TRAILS AT ASPEN RIDGE - STOCKPILE

GRADING & EROSION CONTROL PLANS

EPC'S EDARP FILE NUMBER: CDR2312

TRAILS AT ASPEN RIDGE - STOCKPILE			
CONSTRUCTION DRAWINGS GRADING AND EROSION CONTROL PLANS			
TITLE SHEET			
DESIGNED BY:	NMS	SCALE	DATE ISSUED: MAY 2023
DRAWN BY:	KGJ	HORIZ N/A	DRAWING No. 1 OF 8
CHECKED BY:	RA	VERT. N/A	SHEET 1 OF 8
			DRAWING No. TS01

<b>TRAILS AT ASPEN RIDGE - STOCKPILE</b>			
CONSTRUCTION DRAWINGS GRADING AND EROSION CONTROL PLANS			
<b>GRADING AND EROSION CONTROL PLAN</b>			
DESIGNED BY:	NMS	SCALE	DATE ISSUED: MAY 2023
DRAWN BY:	TRS	HORIZ N/A	DRAWING No. GEC01
CHECKED BY:	NMS	VERT. N/A	SHEET 3 OF 8

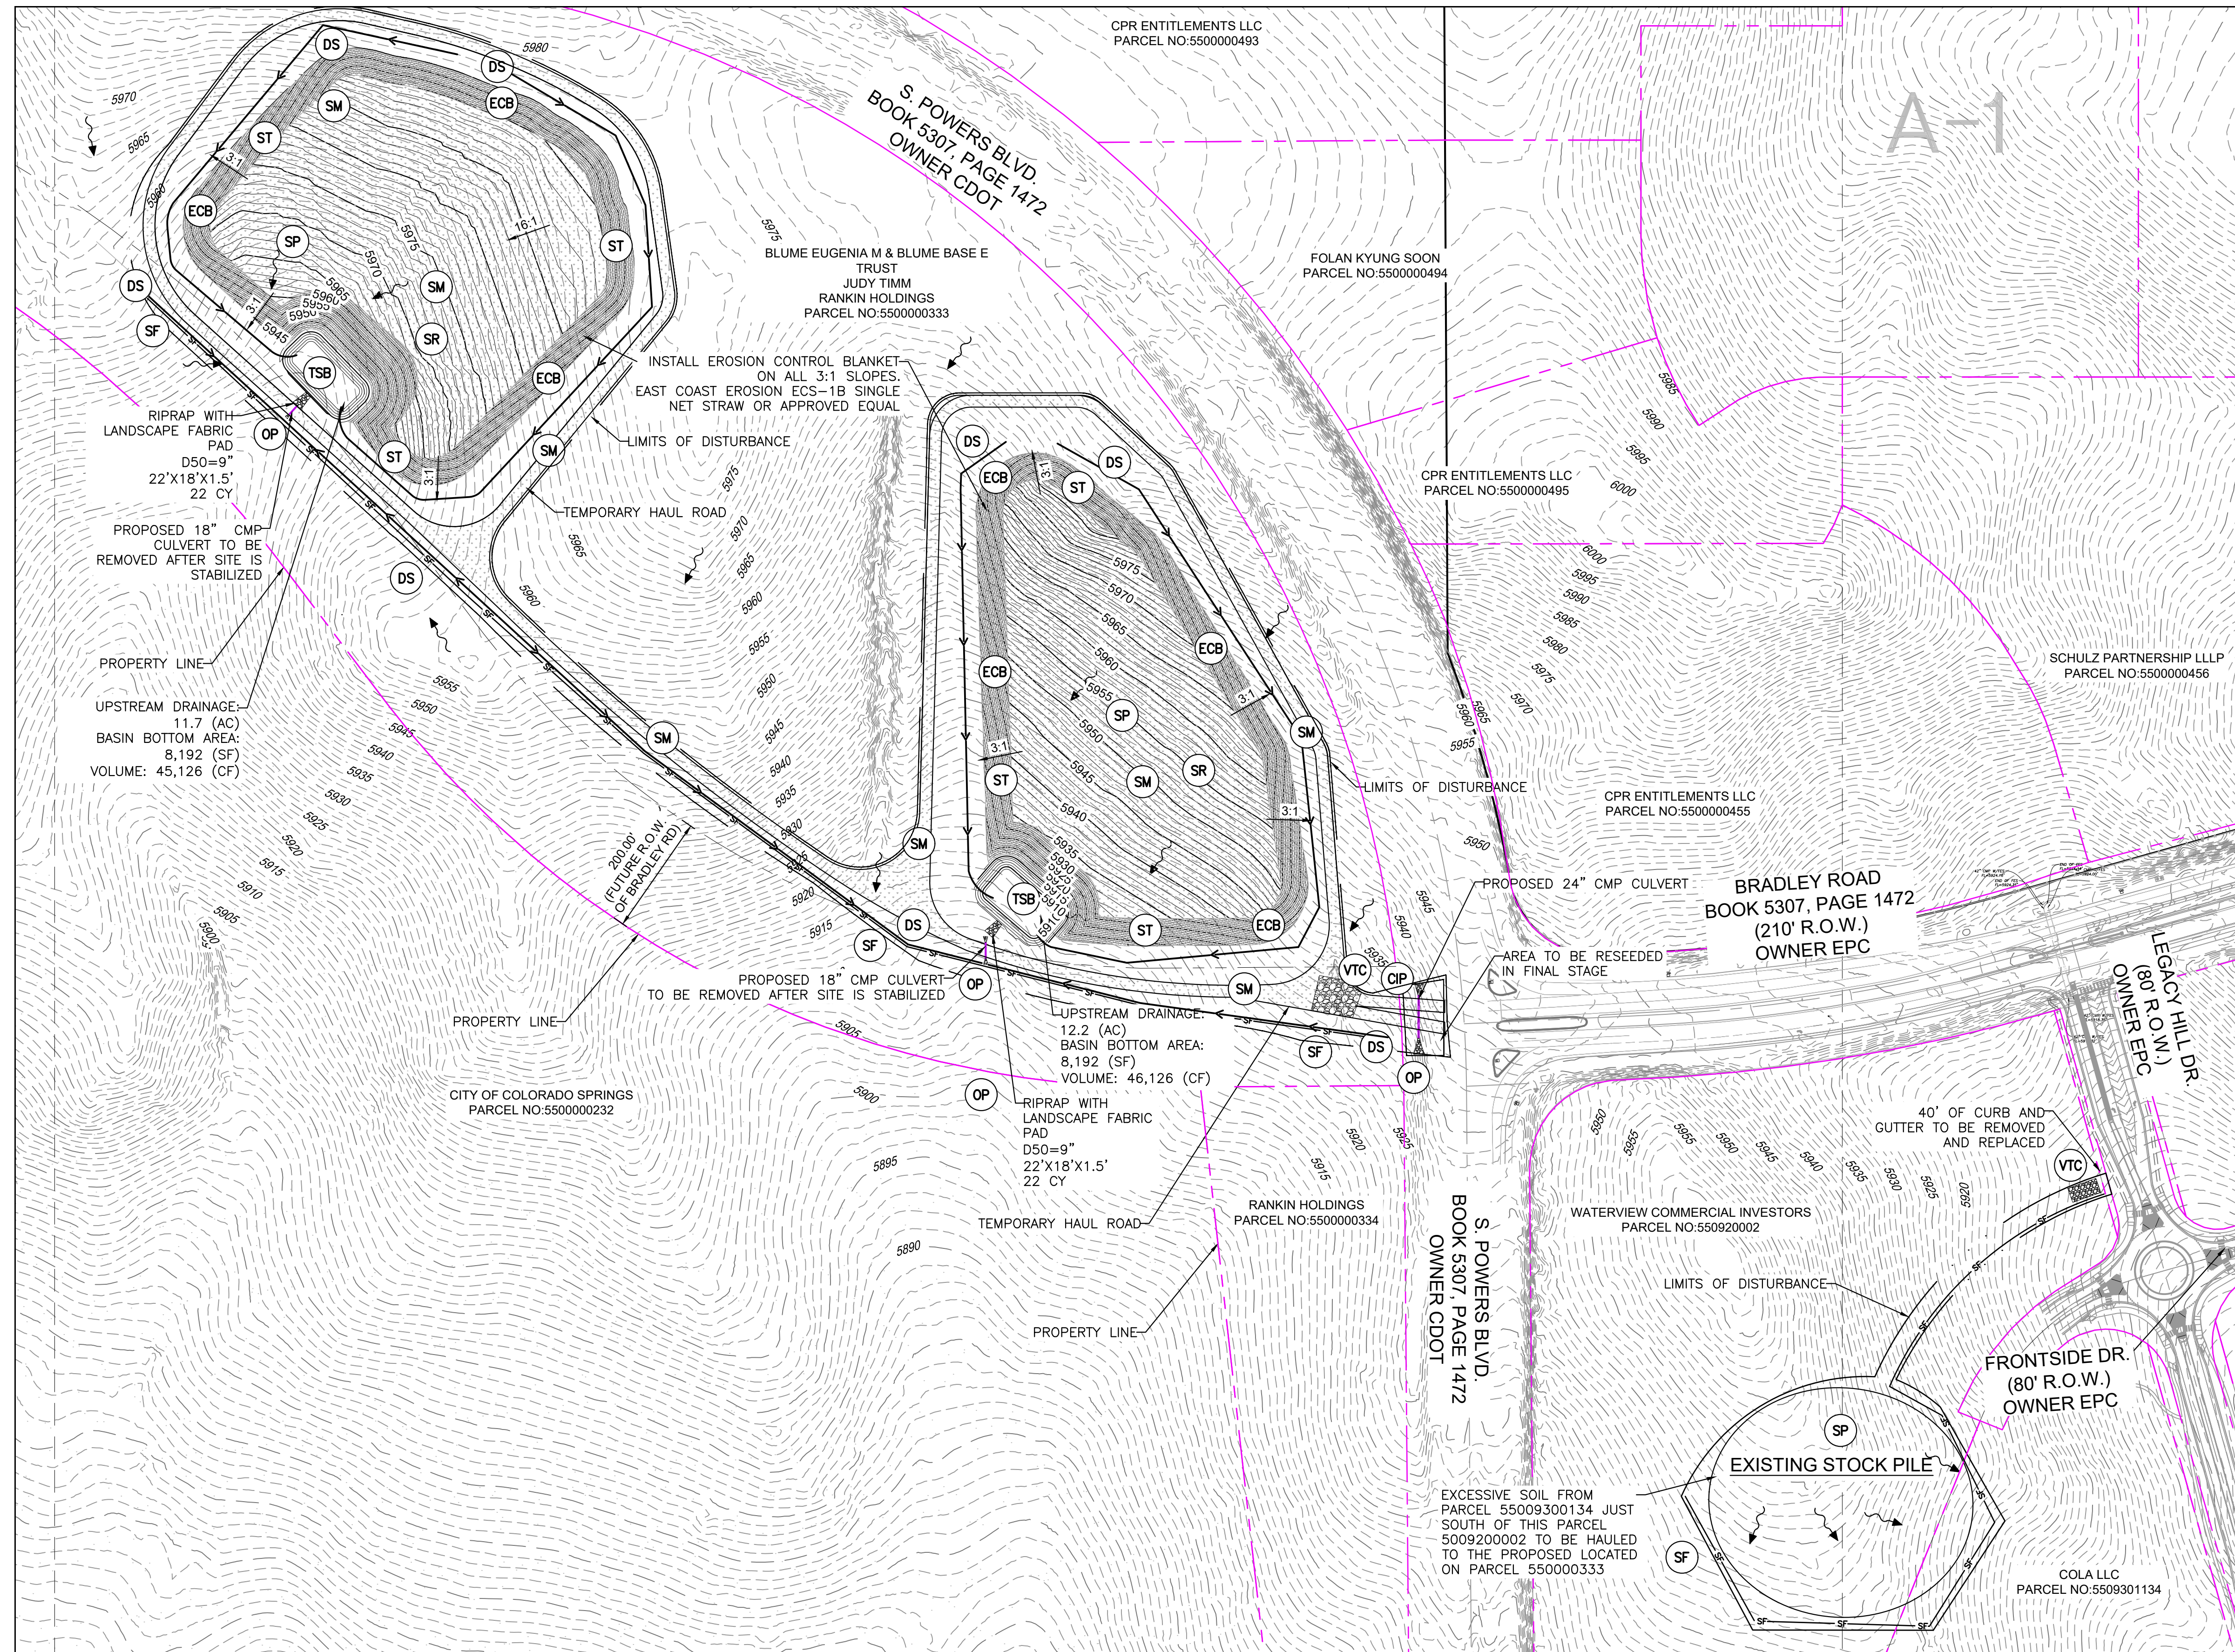
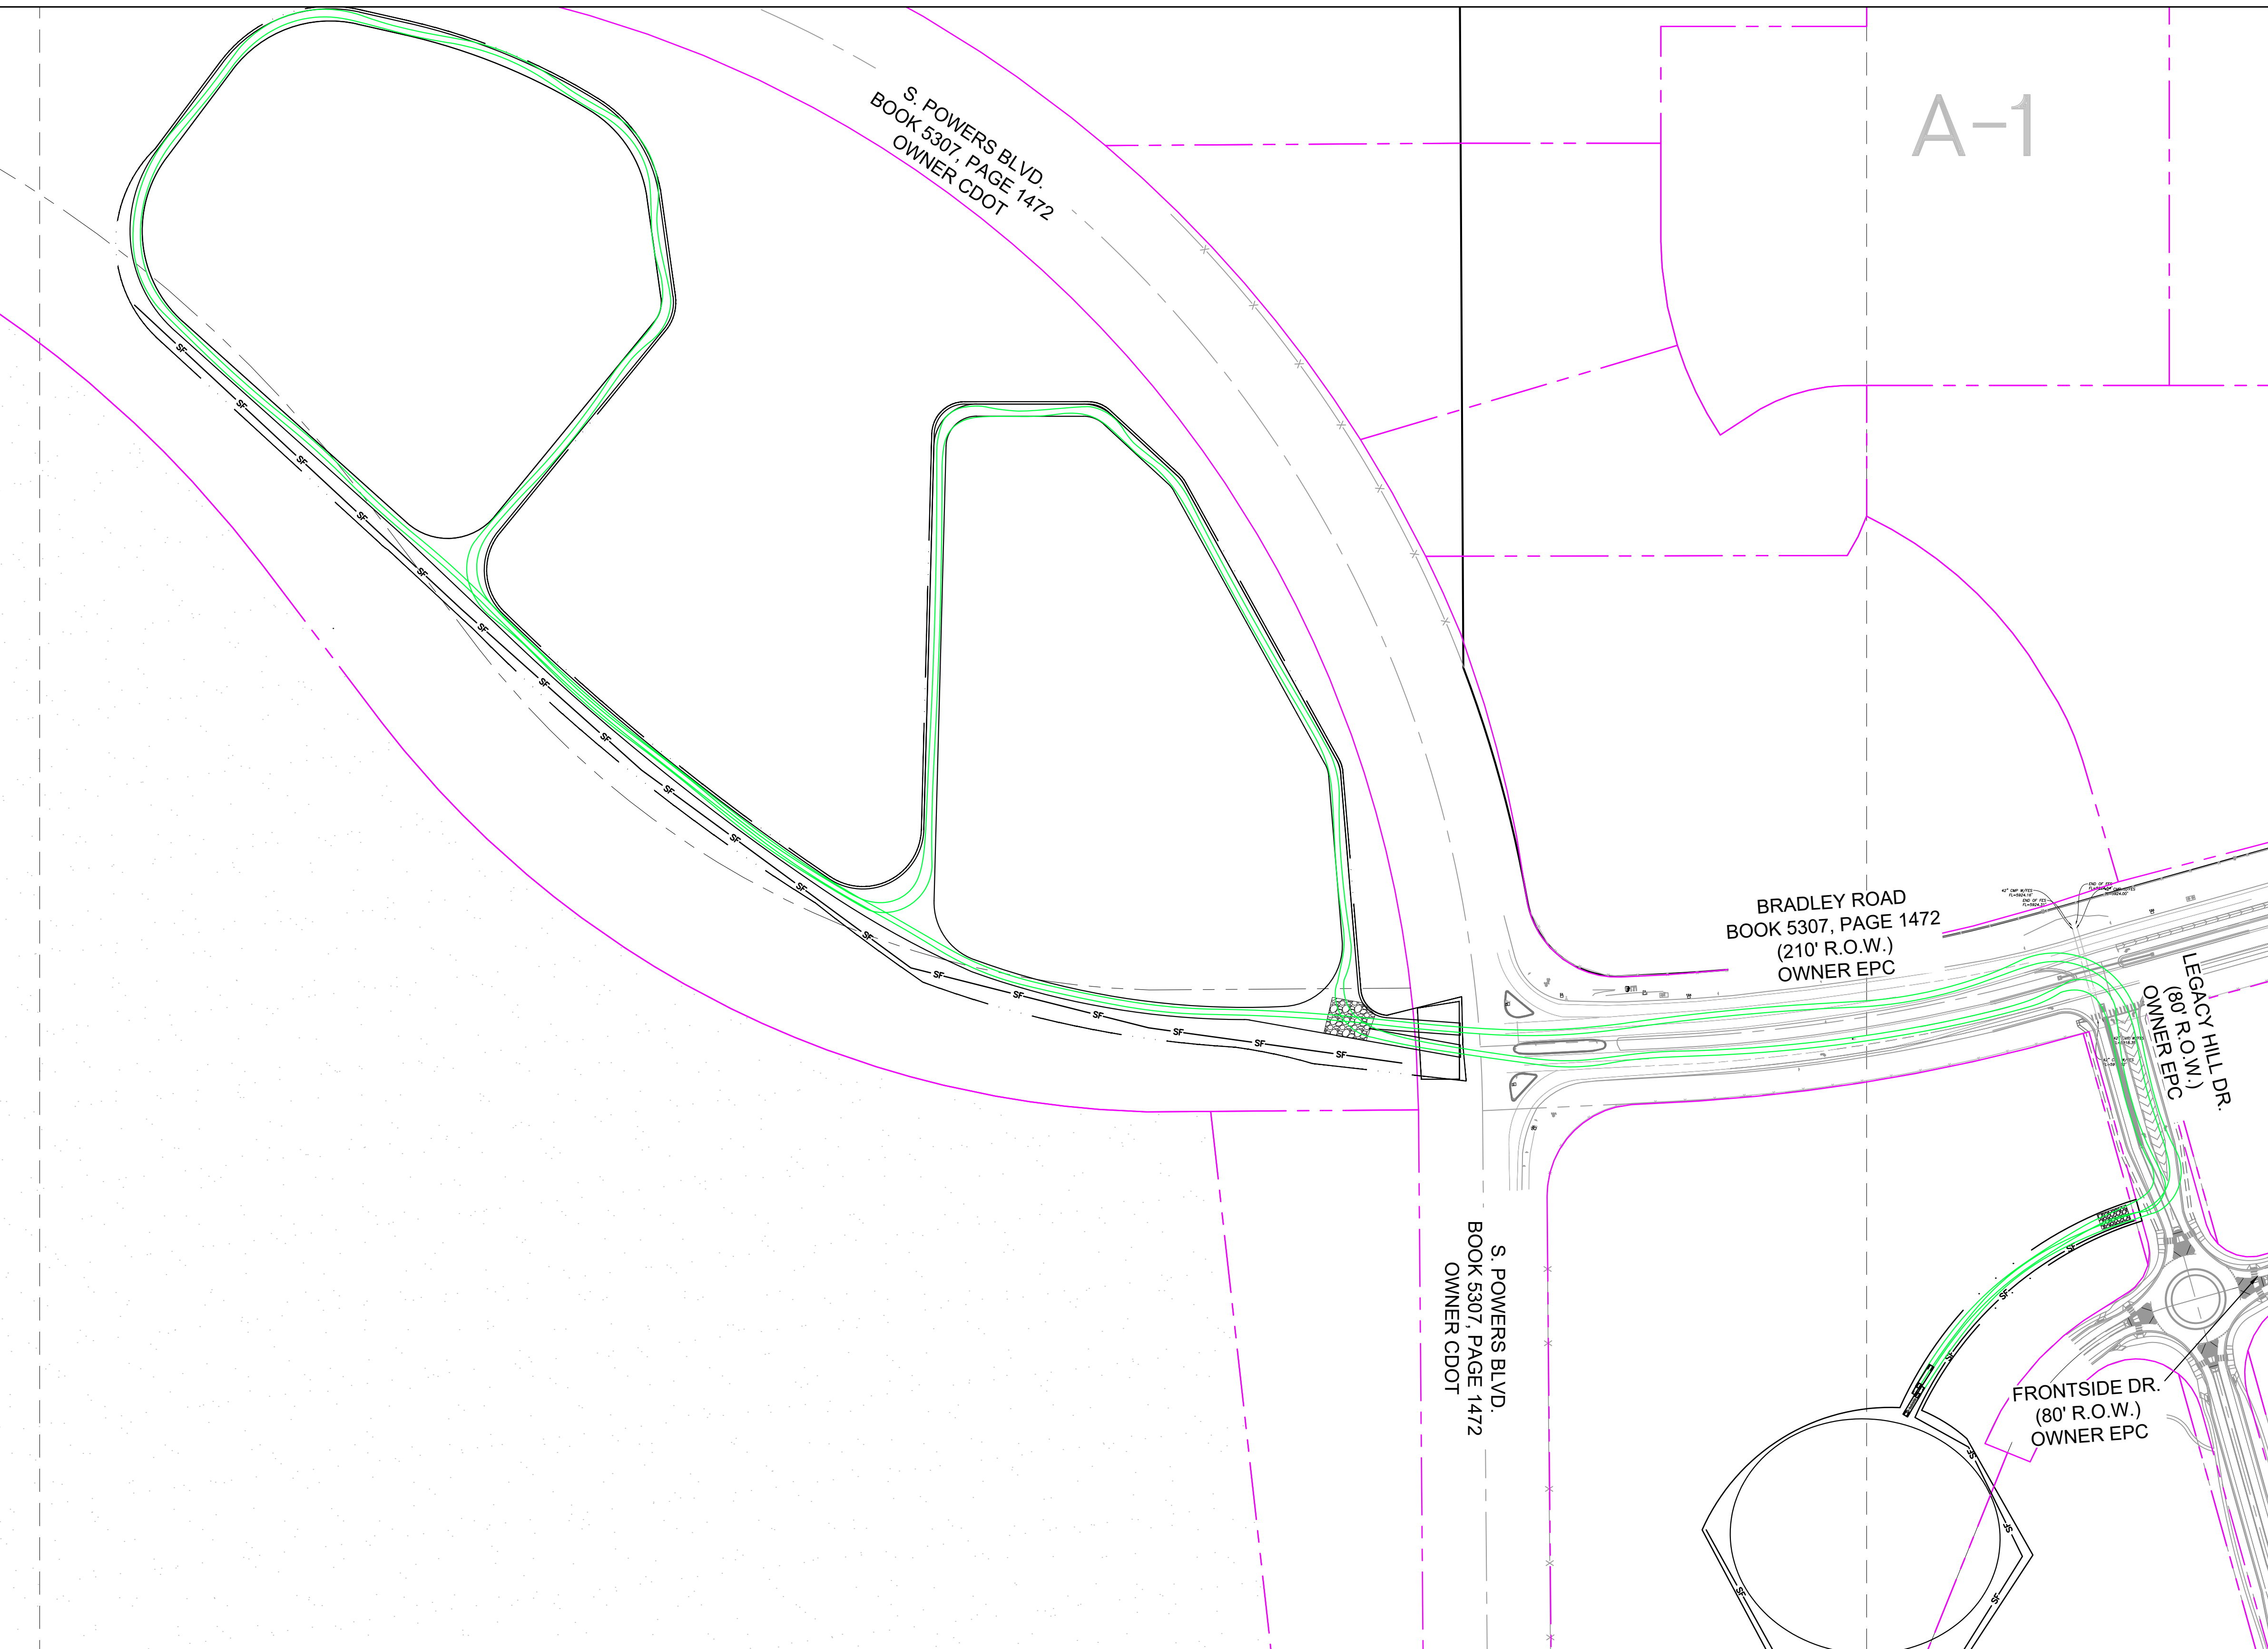
Please also add TSB to the list of Final BMPs below. We think it'd be best to just leave them in place and seed them when the stockpiles are complete.

Swale needs to be installed in interim phase (soon after installation of TSB and hauling begins) in order to convey runoff from all vegetated soils to TSBs.

It's unclear what the intended difference is between these two notes is, especially since a Landscape Plan was not submitted. Revise to clarify.

Likely just need one note for seeding req's that summarizes or references DCMv2 - Section 3.2 - General Principles - Basic Grading, Erosion and Stormwater Quality Requirements and General Prohibitions #16:

Note: A notice/correspondence with City of Colorado Springs regarding the installation of culverts in City land is required.

Show and label right-of-way lines. Label ROW owner (CDOT, EPC)
